CONSERVATION & DESIGN COMMENTS

Application No: 23/00908/FLH	Date of comment: 4.10.2023
Location: 21 The Headway Ewell Surrey KT17 1UN	
Proposal: Landscaping alterations to front driveway incorporating entrance gates and scrubs fencing to property boundary. Swimming pool to rear garden.	
Conservation area: Ewell Village with Article 4 Direction	
Consultee: Justine Page	
Site visit: 3.10.2023

Proposed & Existing Driveway
Side Elevations (Road Side)

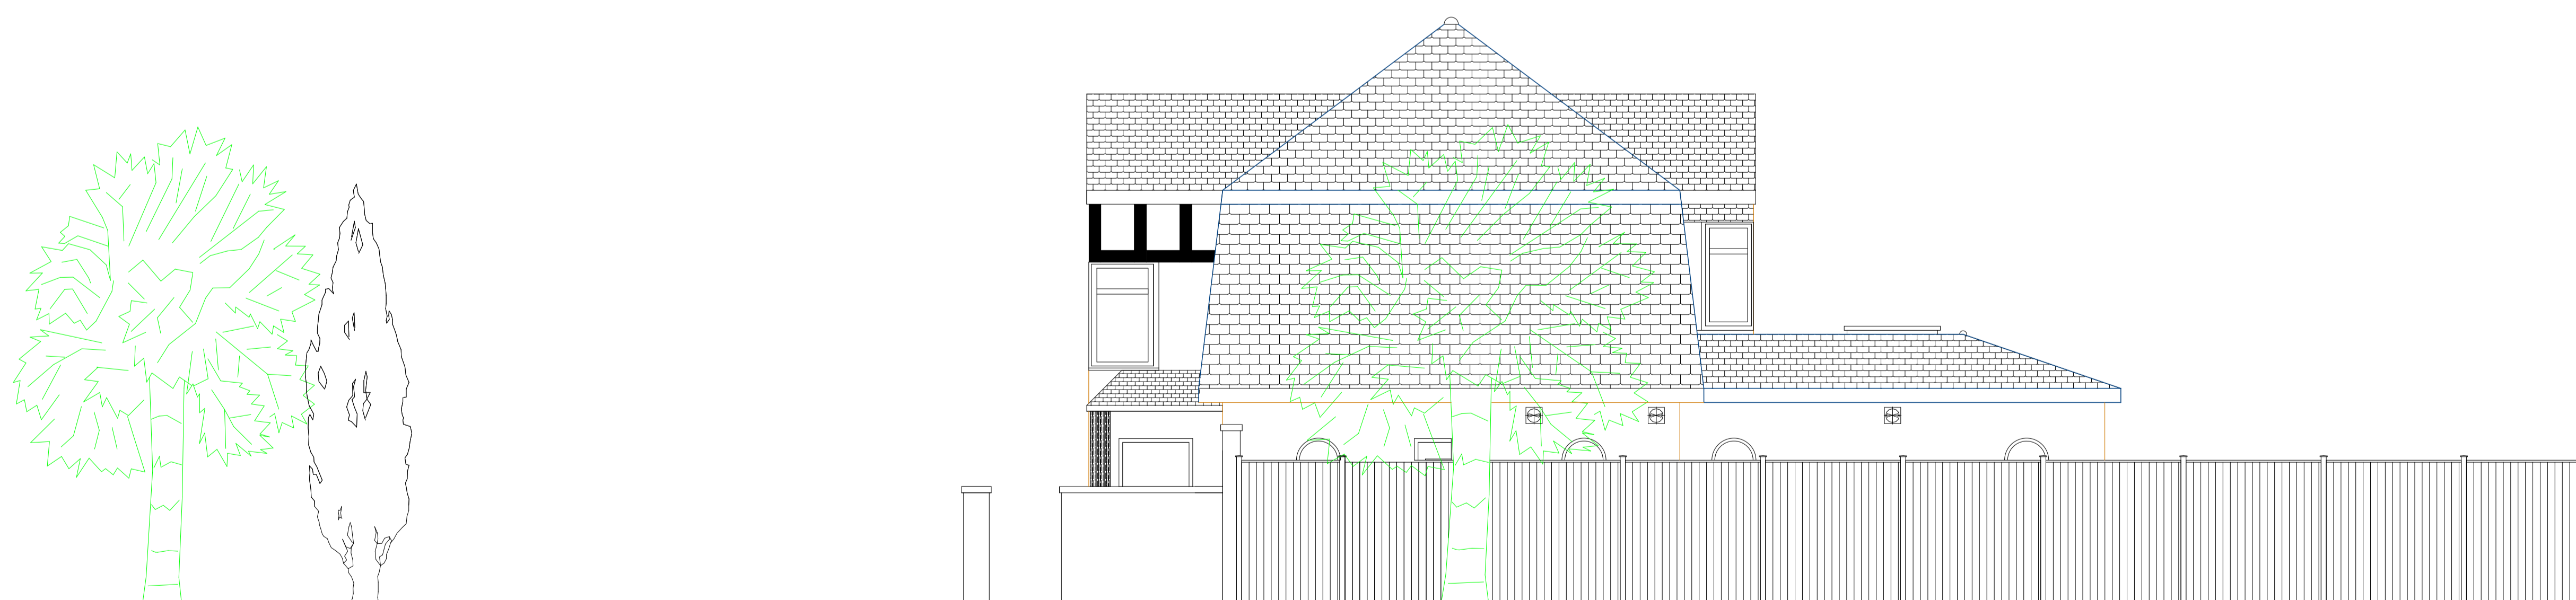
Detailed comment: This open landscaping however is such a strong feature of this part of the conservation area that it would be harmful to enclose the front garden with any type of boundary, and I therefore have to object to this application.

Proposed plan no. ITE-201028-PS-0016 (for the swimming pool) shows a fence proposed fence hidden in the proposed hedging. The two proposed large solid gates proposed are not represented anywhere else in The Headway, and they would be visually intrusive, solid in appearance and serve to block the landscaped front garden from the public realm which is a key feature of the character of this part of the conservation area.

AGENT REPLY: Based on this feedback my client is willing to remove the solid gates however would be similar in design to the below image found on The Headway, taking into consideration of the road a farm fencing design gate would be extremely in keeping and not to be mistaken for modern additions also found on The Headway. You can see examples of gates on The Headway as noted below in a variety of types which not all are in keeping. Hence I struggle to understand that this wouldn't be in keeping with the character of the road. This should be reconsidered. With regards to the notes about fencing on ITE-201028-PS-0016 hidden in the proposed hedging, clarity should be sought to understand the drawing and this as this only is serving as a boundary line as noted clearly in text on the submission.
